CITY OF ALBUQUERQUE

January 24, 2022

**Re: Blue Cross Veterinary Clinic
1650 University NE
Traffic Circulation Layout
Architect's Stamp 11-19-2021 (H15-D015B)**

TRAFFIC CIRCULATION LAYOUT

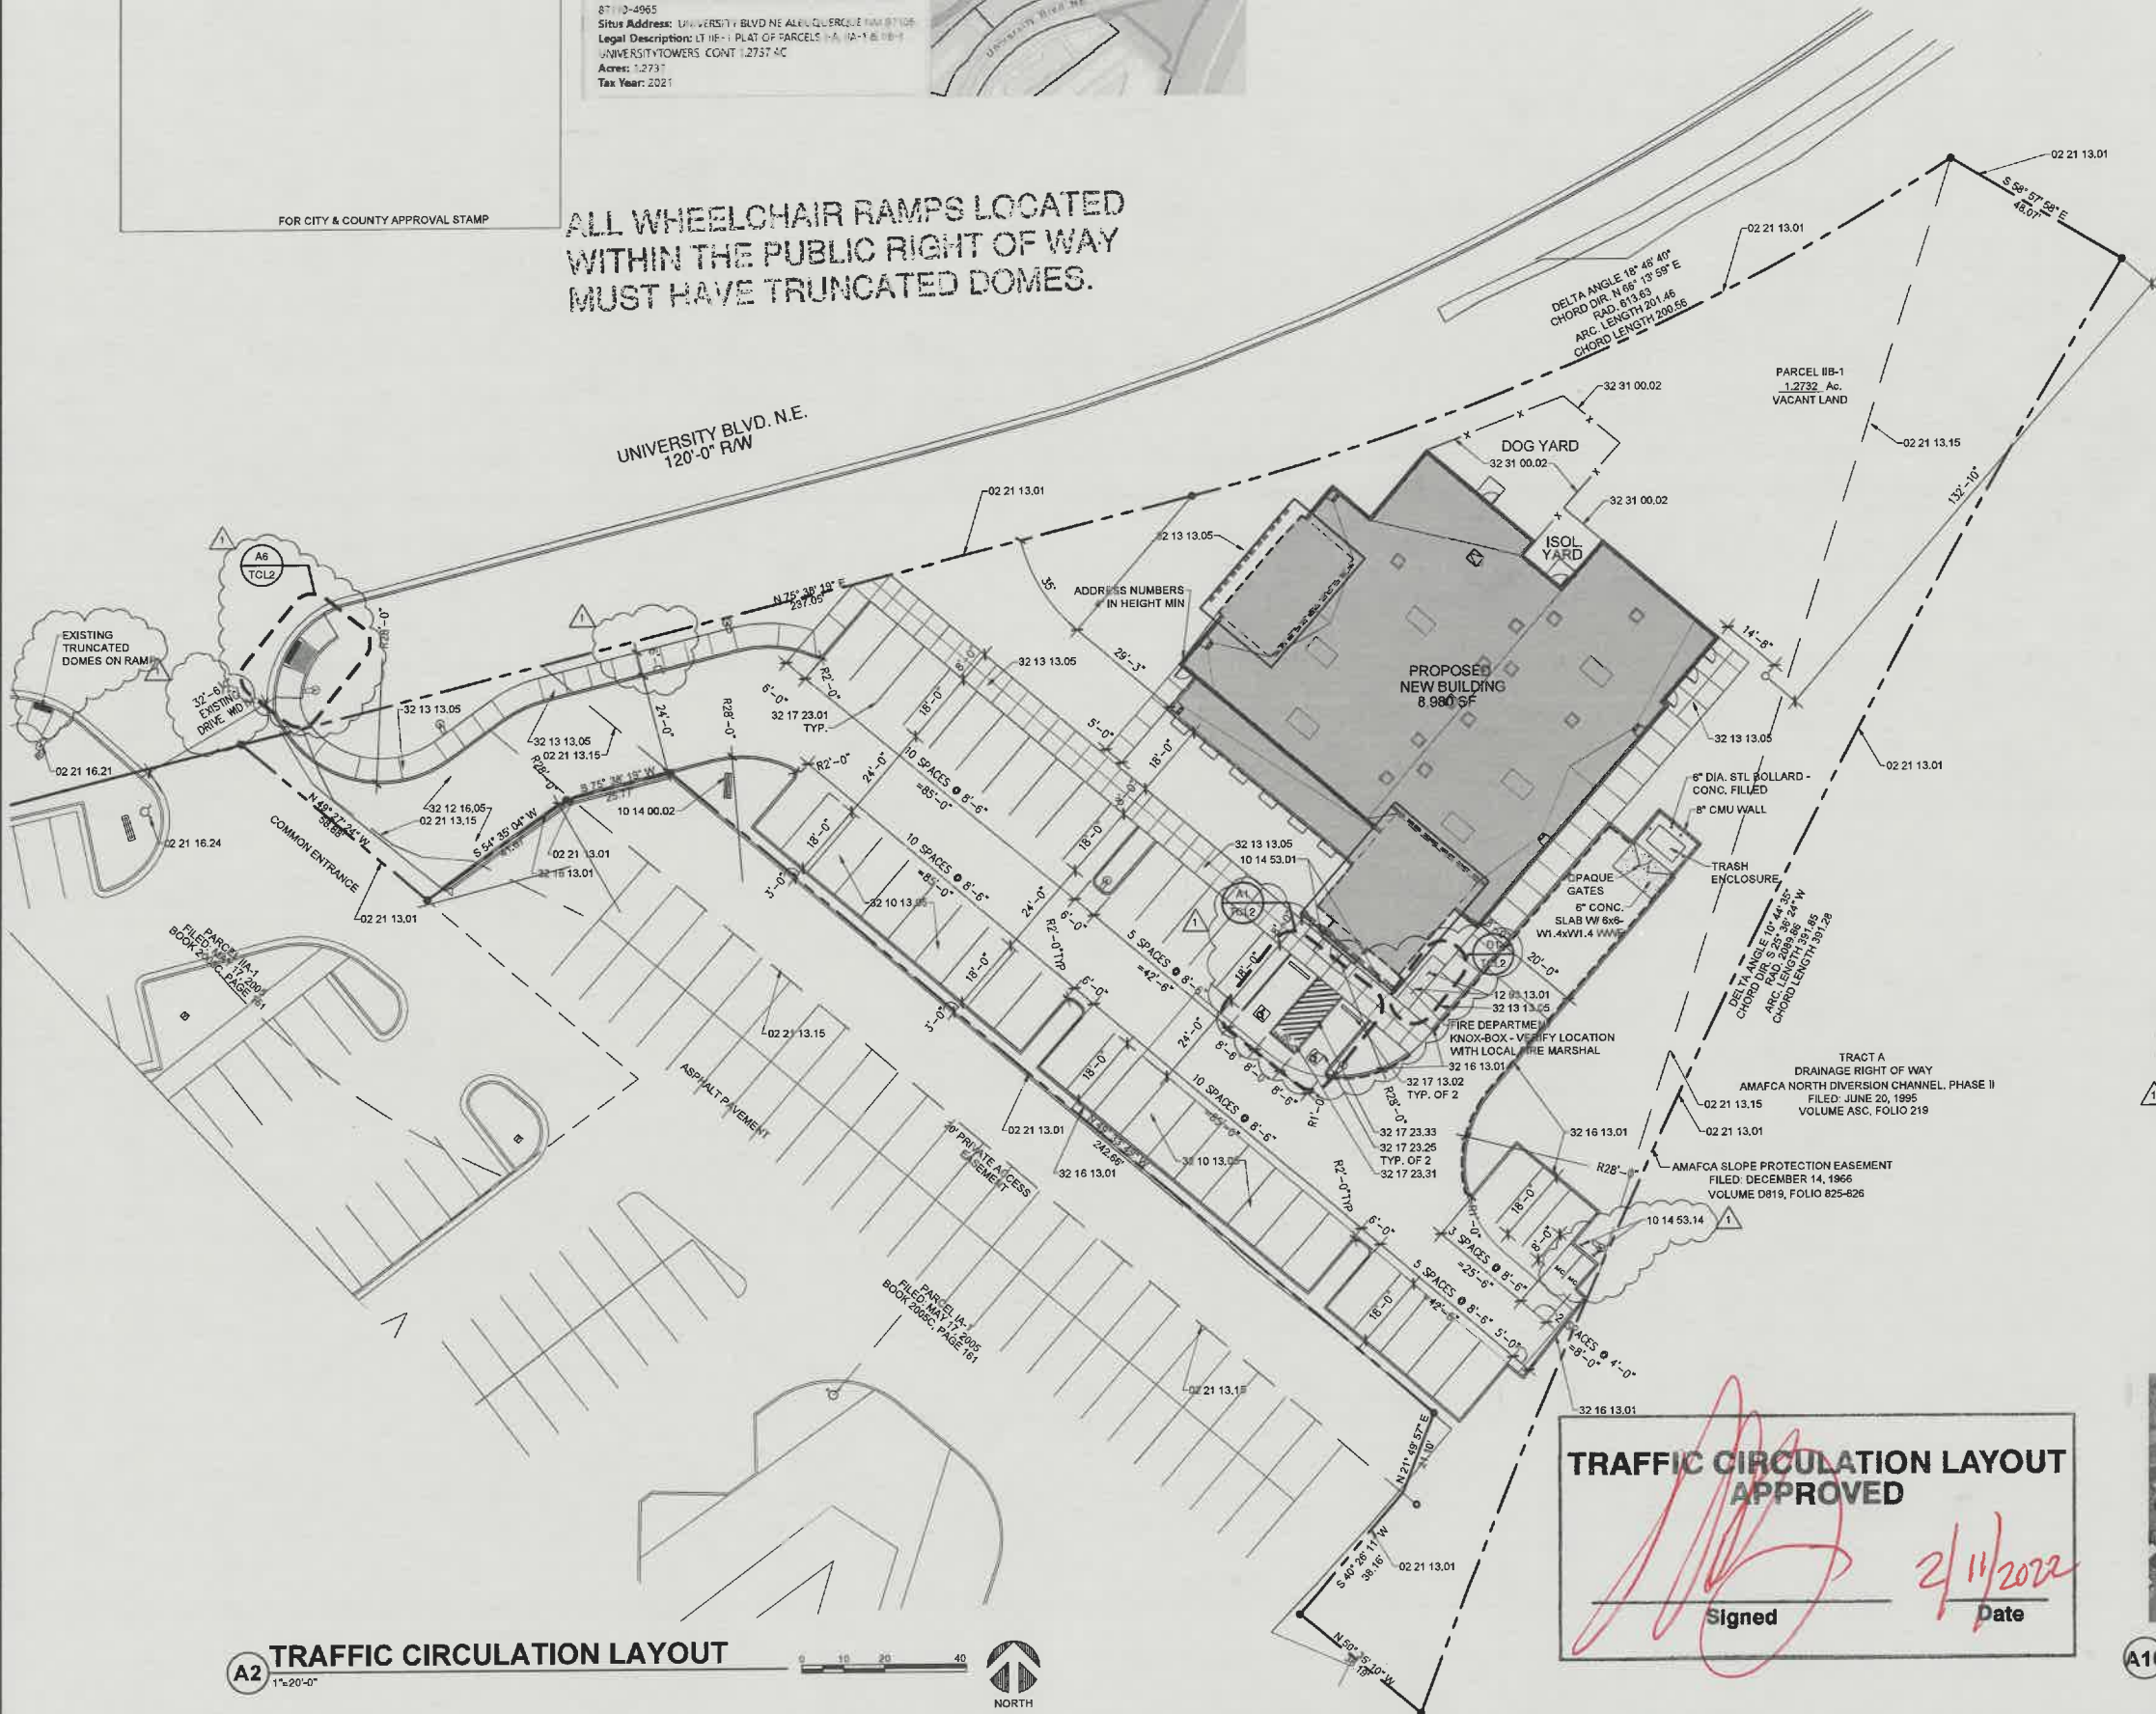
1. Listed are the number of parking spaces required by the IDO as well as the proposed number of parking spaces including bicycle and motorcycle parking.
Coordinate/discuss with Zoning.

2. Provide existing drive entrance width.
3. Identify with keyed notes the two proposed ADA parking stall with ADA signage.
4. The ADA accessible parking sign must have the required language per 66-7-352.4C NMSA 1978 **"Violators Are Subject to a Fine and/or Towing."** Please call out detail and location of signs.

5. The ADA access aisles shall have the words **"NO PARKING"** in capital letters, each of which shall be at least one foot high and at least two inches wide, placed at the rear of the parking space so as to be close to where an adjacent vehicle's rear tire would be placed. (66-1-4.1.B NMSA 1978). **Provide pavement markings details. Provide access aisle striping details as well.**

6. **Main Entrance Existing Ramp:** ADA curb ramps must be updated to current standards and have truncated domes installed. **Please verify.**
7. Motorcycle parking spaces: shall be designated by its own conspicuously posted upright sign, either free-standing or wall mounted per the zoning code. Provide sign face and pavement MC details.

8. **All bicycle racks shall be designed according to the following guidelines:**
 - a. The rack shall be a minimum 30 inches tall and 18 inches wide.
 - b. The bicycle frame shall be supported horizontally at two or more places. Comb/toaster racks are not allowed.

- 17. Please provide a sight distance exhibit
- 18. Show the clear sight triangle and add the following note to the plan: "Landscaping and signage will not interfere with clear sight requirements. Therefore, signs, walls, trees, and shrubbery between 3 and 8 feet tall (as measured from the gutter pan) will not be acceptable in the clear sight triangle."

- 19. Please specify the City Standard Drawing Number when applicable.
- 20. Shared Site access: driveways that straddle property lines, or are entirely on one property but are to be used by another property, shall have an access easement. Please include a copy of your shared access agreement with the adjacent property owner.

- 21. Add a note stating "All broken or cracked sidewalk must be replaced with sidewalk and curb & gutter." A build note must be provided referring to the appropriate City Standard drawing (2430 & 2415A).
